Your Ref: OWPC14793
Our Ref: AL/75/17/A 28-06-2017
Please ask for:
Richard Temple

Town & Country Planning (Control of Advertisement) (England) Regulations 2007 (as amended)

2 No. flag poles & 1 No. 'V' sign board
Land opposite Woodgate & 2 Hook Lane Aldingbourne

1no. V-sign

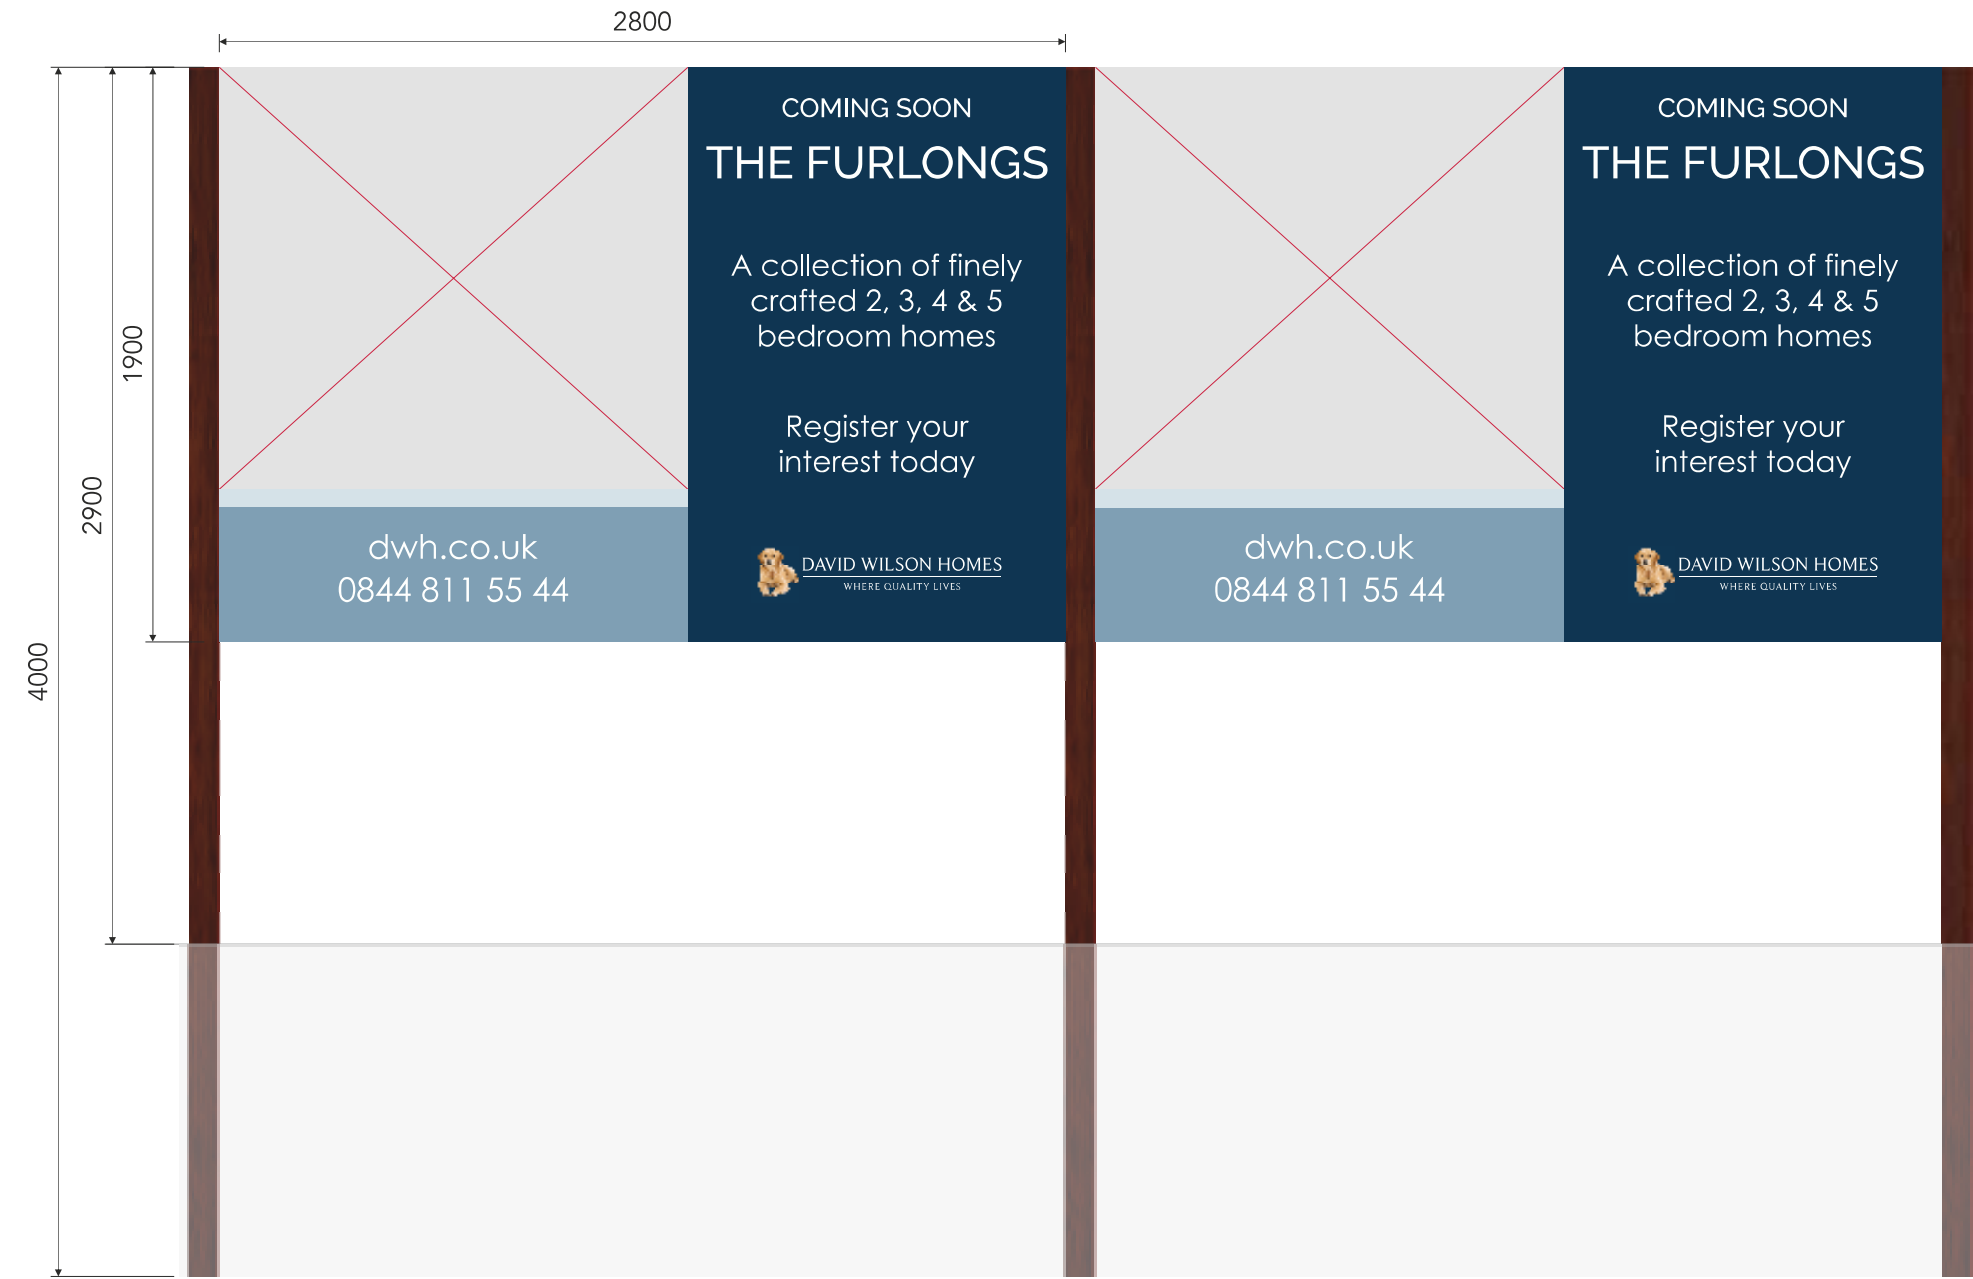
- 1. The signage is far too big for such a narrow lane, and will look totally out of place. The combined length of the V-boards are 18 foot long, 18 foot (5600mm) is far too big. A proper estate agent board would look more in keeping and serve the same purpose. How many accidents will be caused by motorist suddenly stopping to view this monstrosity?*
 - 2. Flag poles 19 1/2 foot high (6000mm) again totally out of keeping with the area. Flags 8 foot high (2500mm) again way over the top.*
- Noise. Have you tried sleeping with a flag flapping all night long? With 16 foot of sailcloth it should keep everyone within a 100 yards well and truly awake, frustrated and annoyed.*
